Response to The Examining Authority's First Written Questions by National Highways Limited
Application by Frodsham Solar Ltd for an Order granting Development Consent for the Frodsham Solar Farm
Planning Inspectorate Reference Number: EN010153

National Highways has extracted from the Examining Authority’s First Written Questions those questions which are addressed to National Highways. National Highways has used the same format table as issued by the ExA with its response provided under each relevant question.

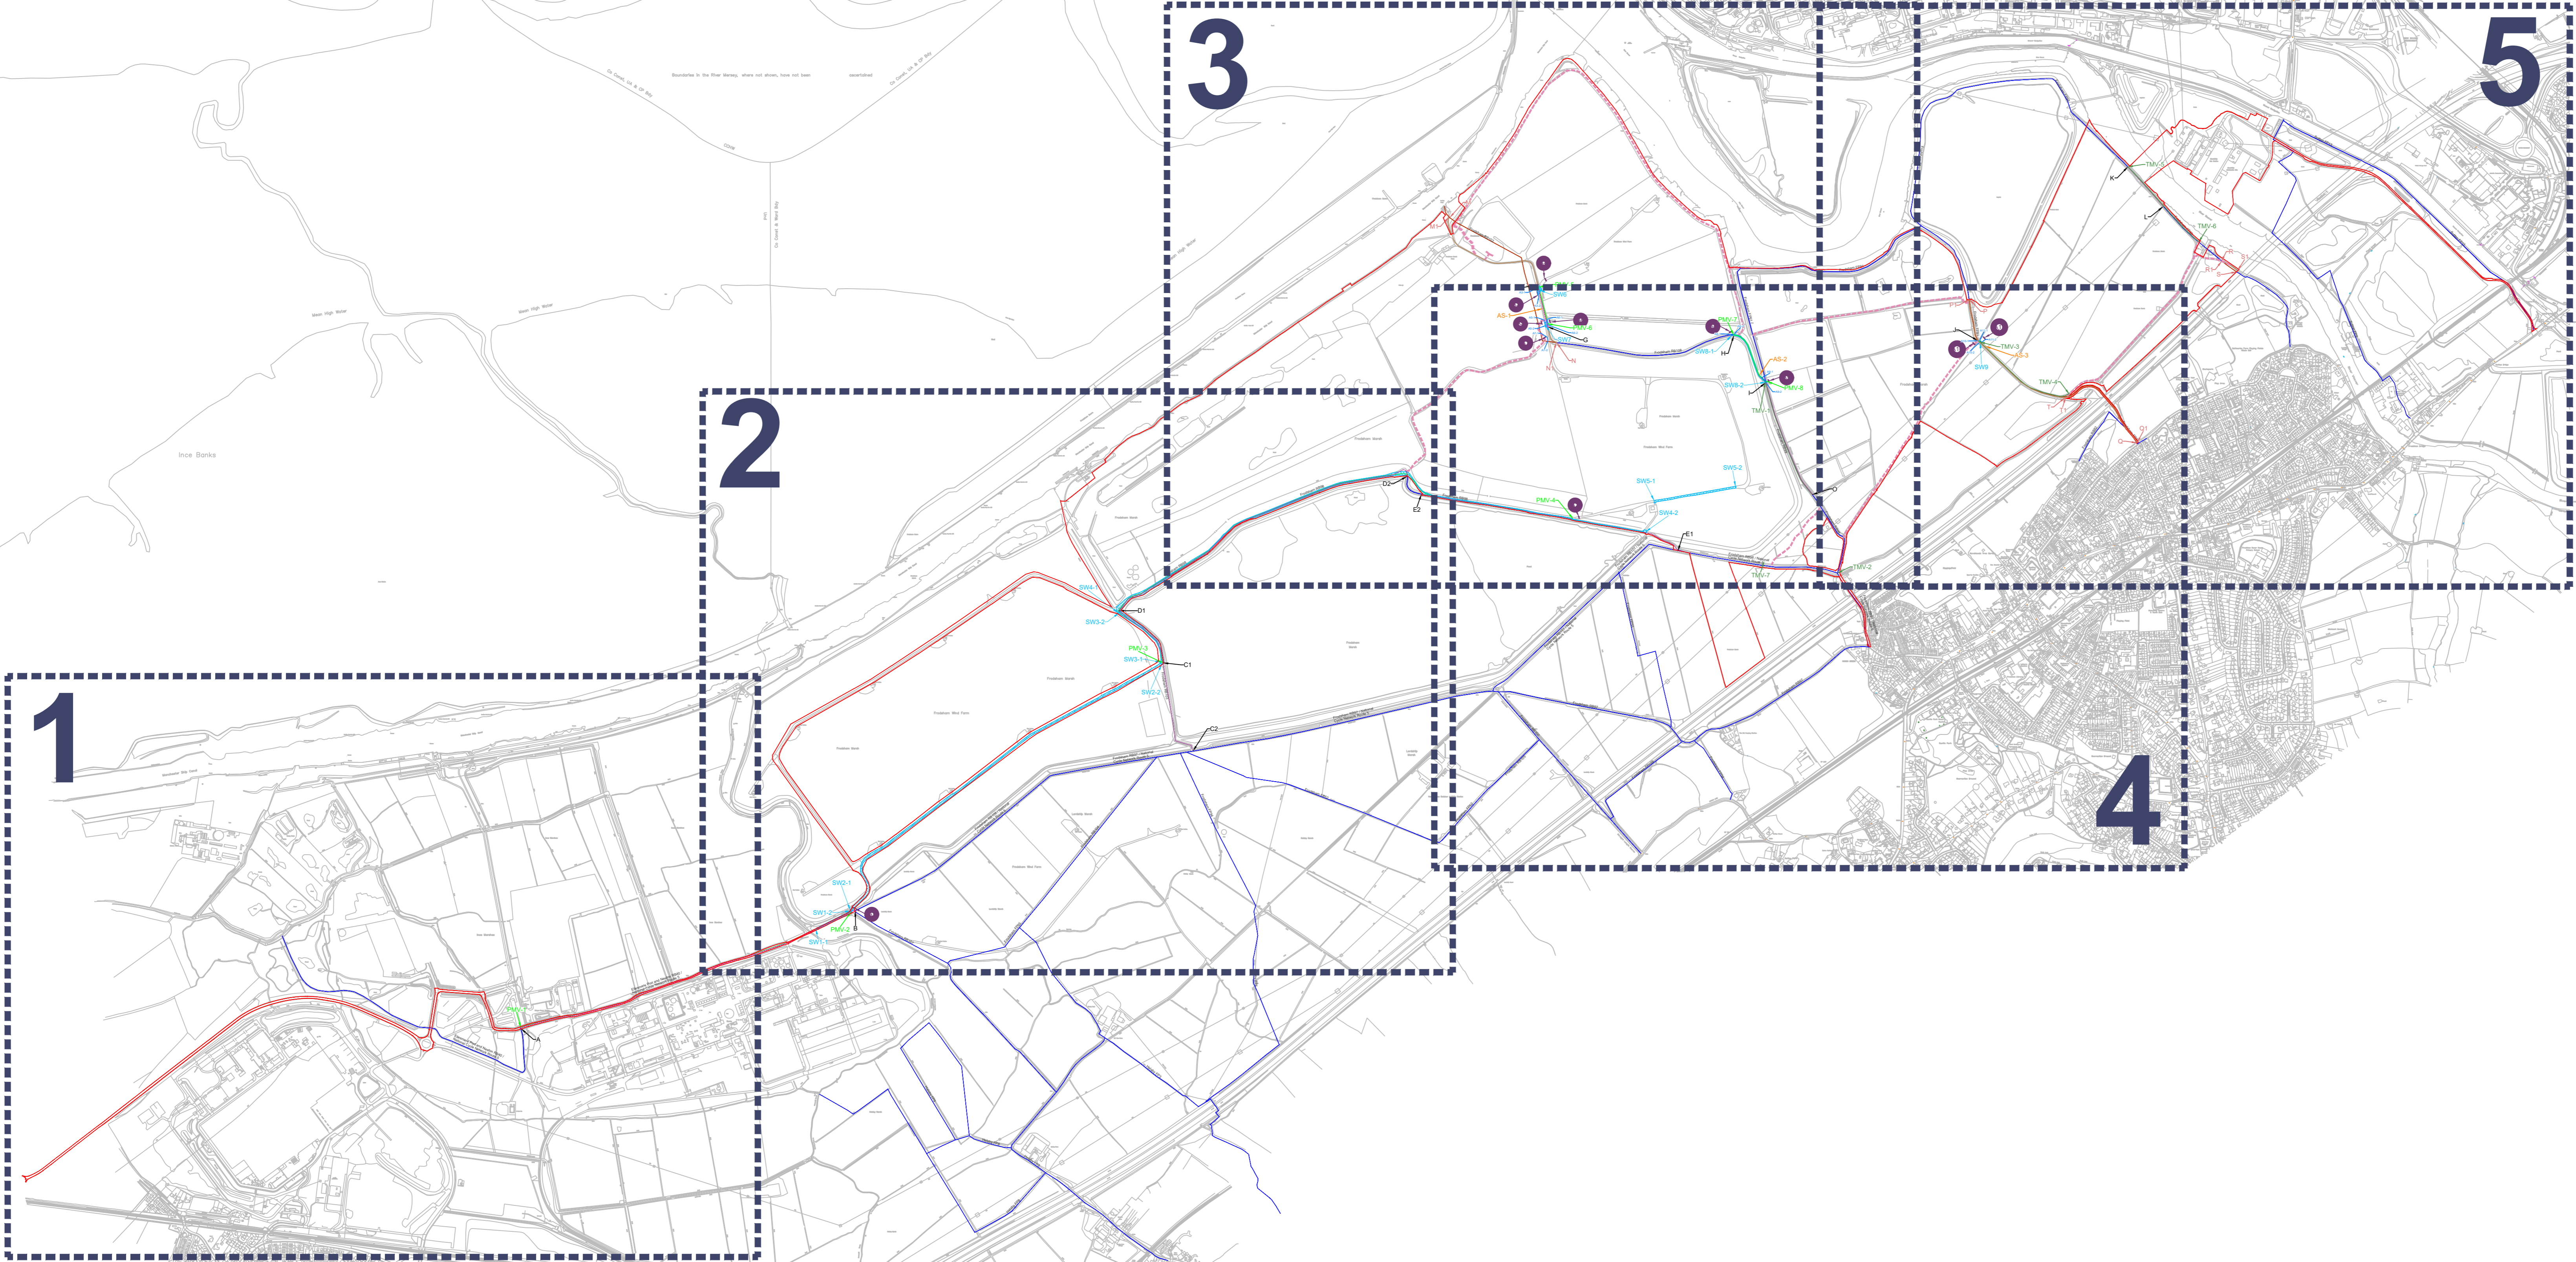
Under dDCO Article 13(3), the undertaker is authorised to permanently stop up Frodsham FP81 (Weaver Lane), as shown by a dark brown line between point P and Q on the street works, public rights of way, vehicular usage and access plans. Article 13(4) goes on to state that it cannot permanently stop up that footpath until it has provided a bridleway along the route shown by a light brown line between points P1 and Q1 on the same plan.

Further to this, Article 13(12), has the effect of authorising emergency service vehicles to use motorised vehicles on Frodsham Footpath 81 (weaver Lane).

These Articles represent clear changes of use and intensification from the current position and NH cannot agree to the proposed changes unless and until evidence is provided, by way of Structural Review/Assessment, to satisfy NH that those changes can be accommodated by its bridge structures.
